**Your Ref** 23/01151/APP

**PROPOSED NON-MATERIAL AMENDMENT TO PLANNING PERMISSION REF. 23/01151/APP AT HMP SPRINGHILL, EDGOTT, AYLESBURY**

Proposed changes to the approved plans are:

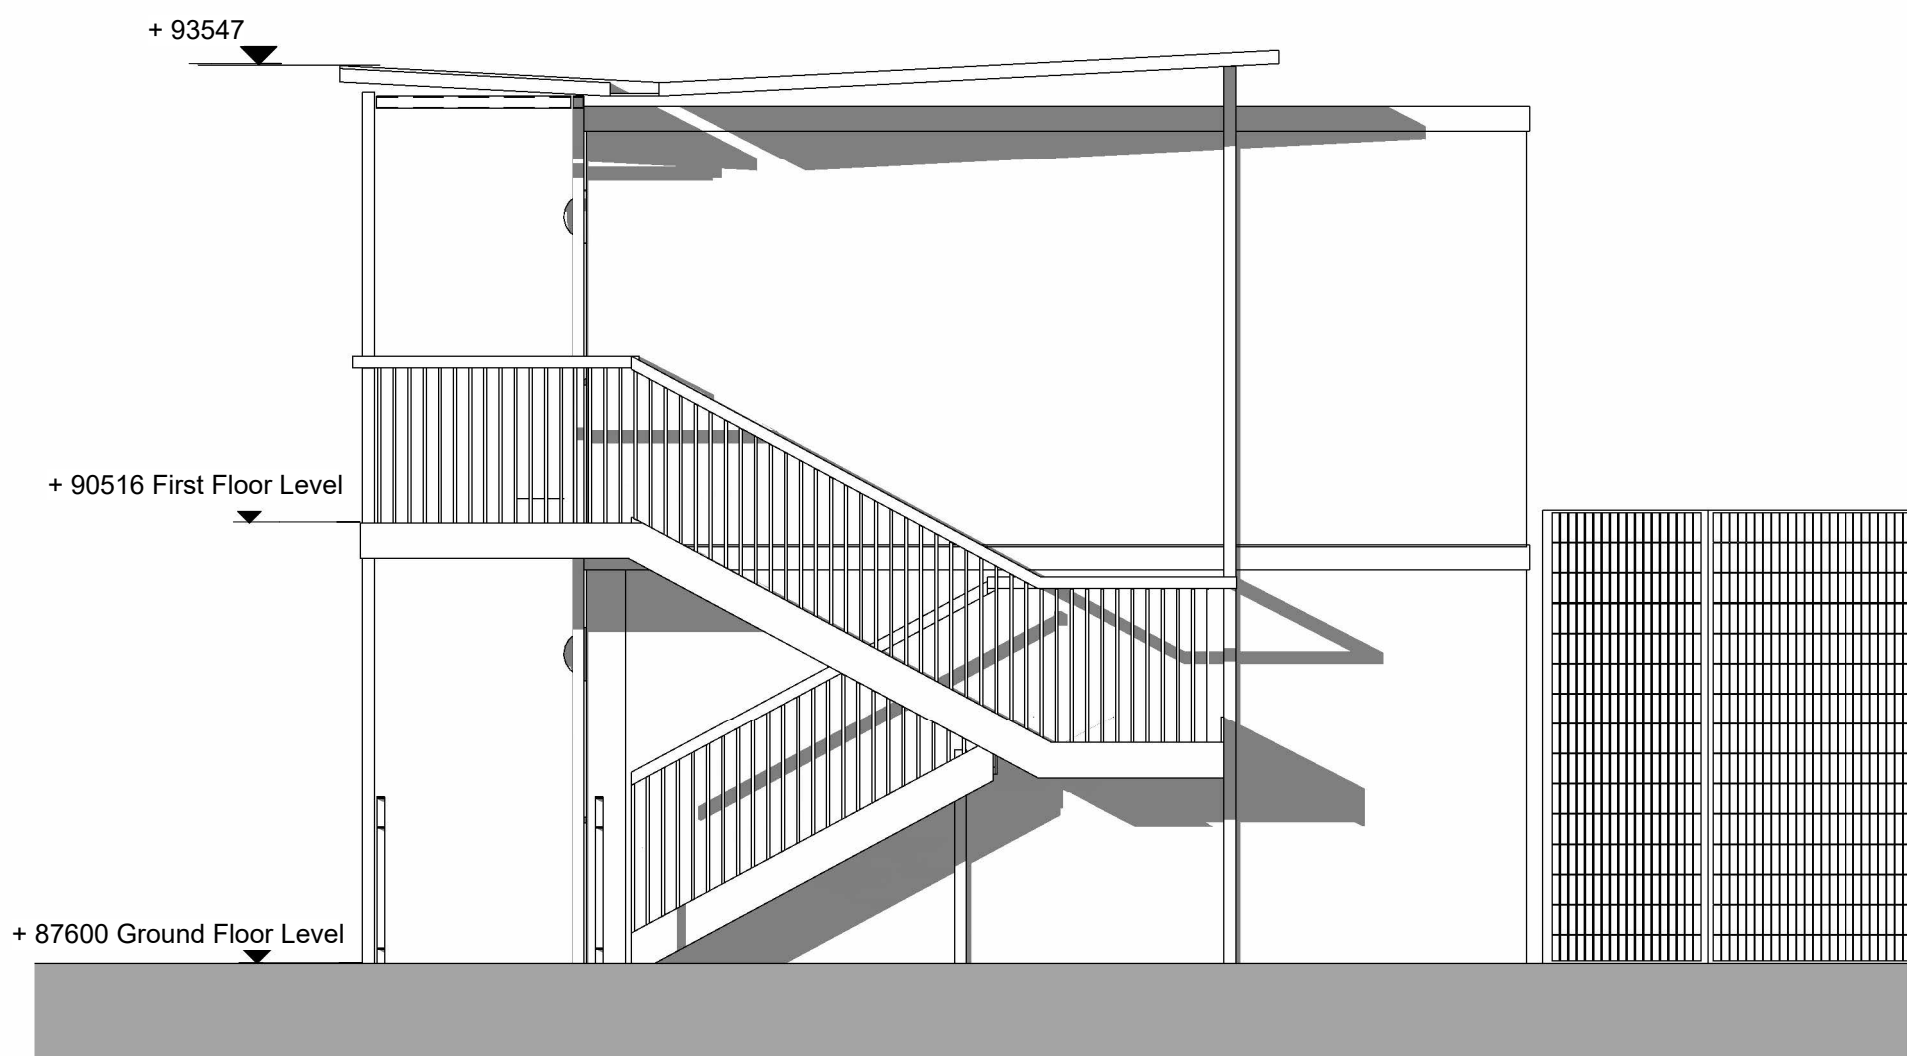
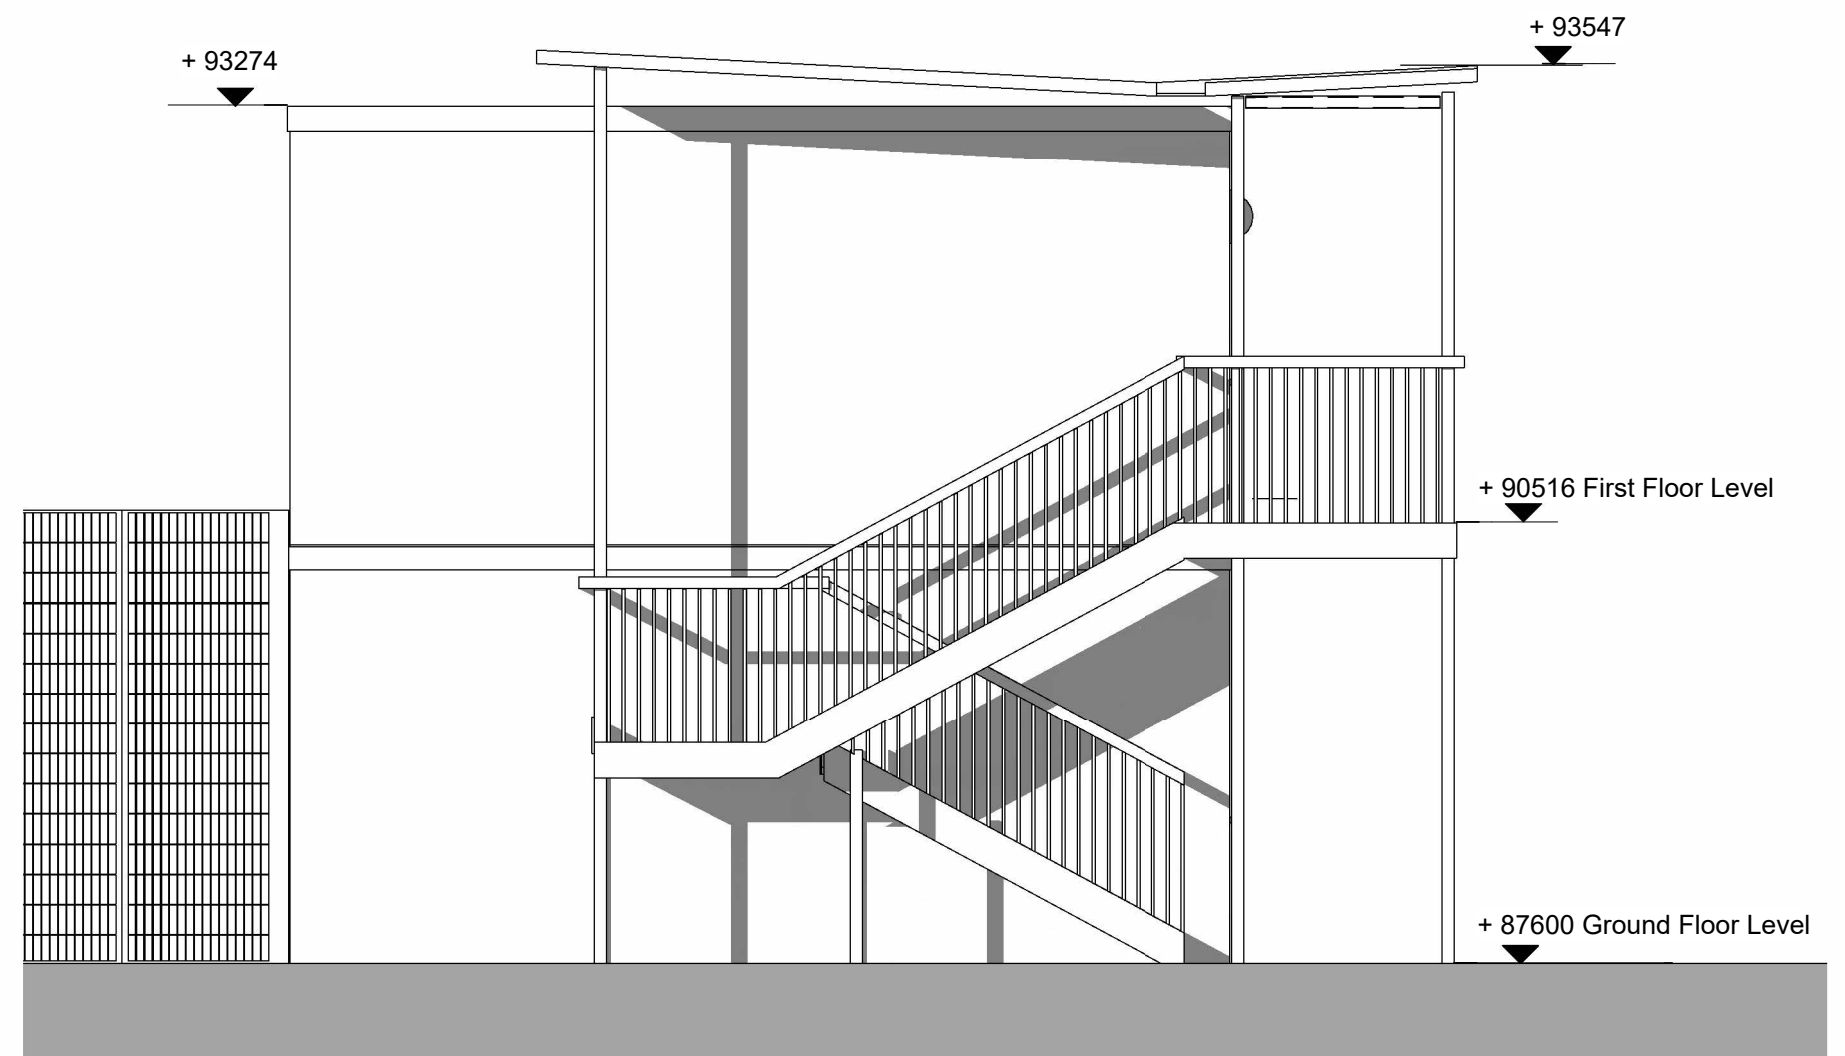
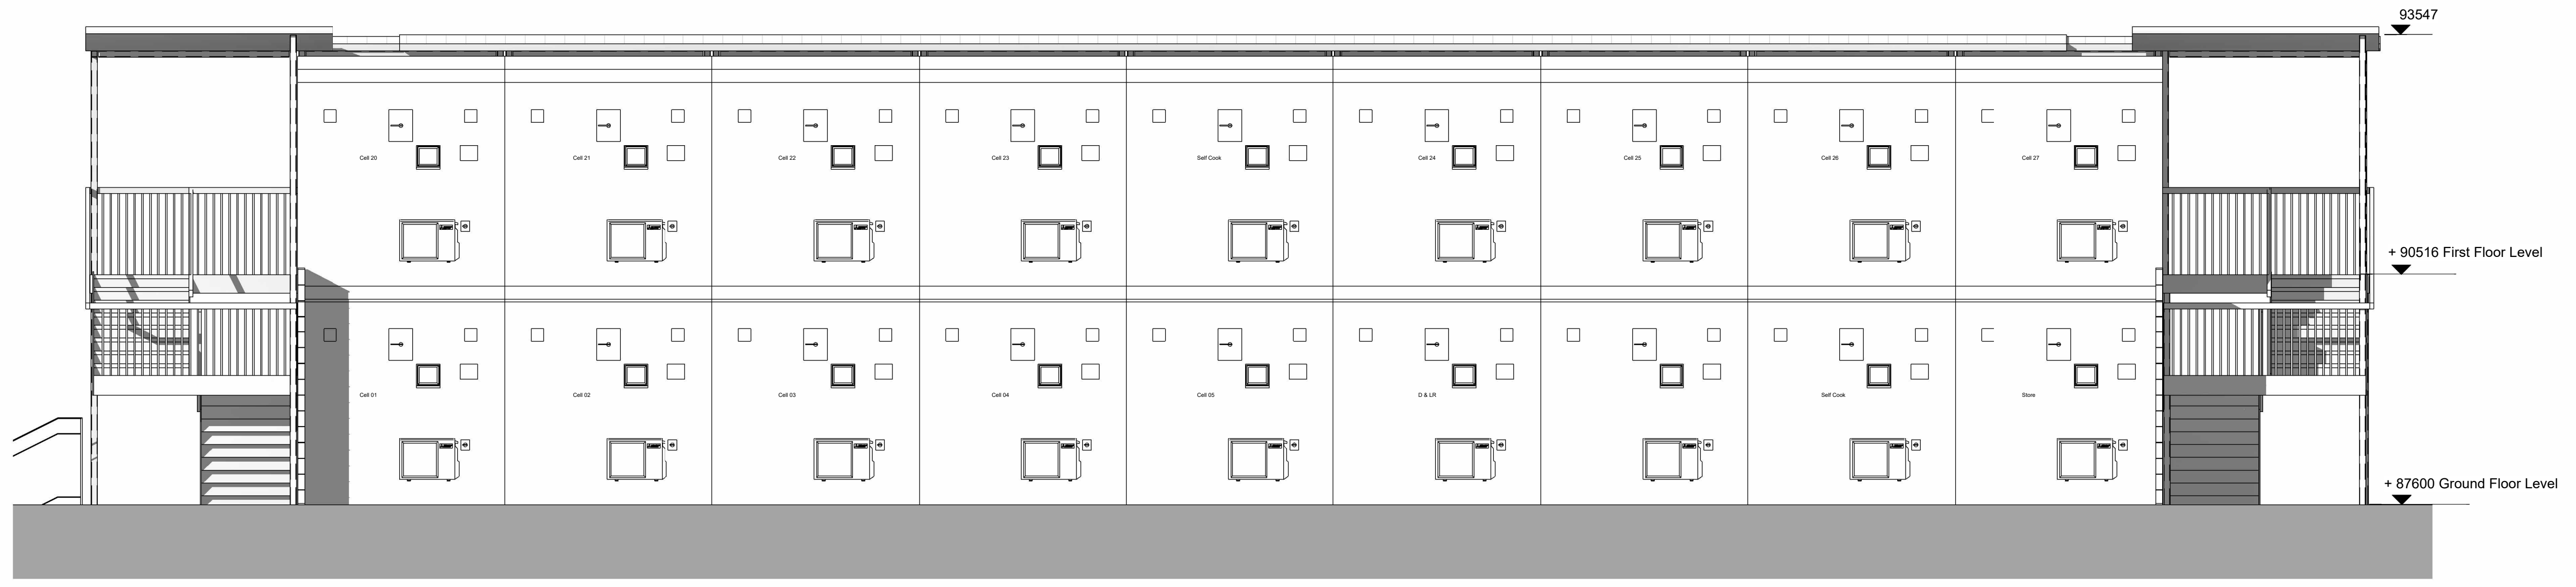
The finished floor levels of blocks 1 & 2 have been raised meaning the ridge is higher in comparison to the original. A step in the level has been removed as a result.

Change in appearance of the railings to the walkways (originally perforated sheets, now vertical slats).
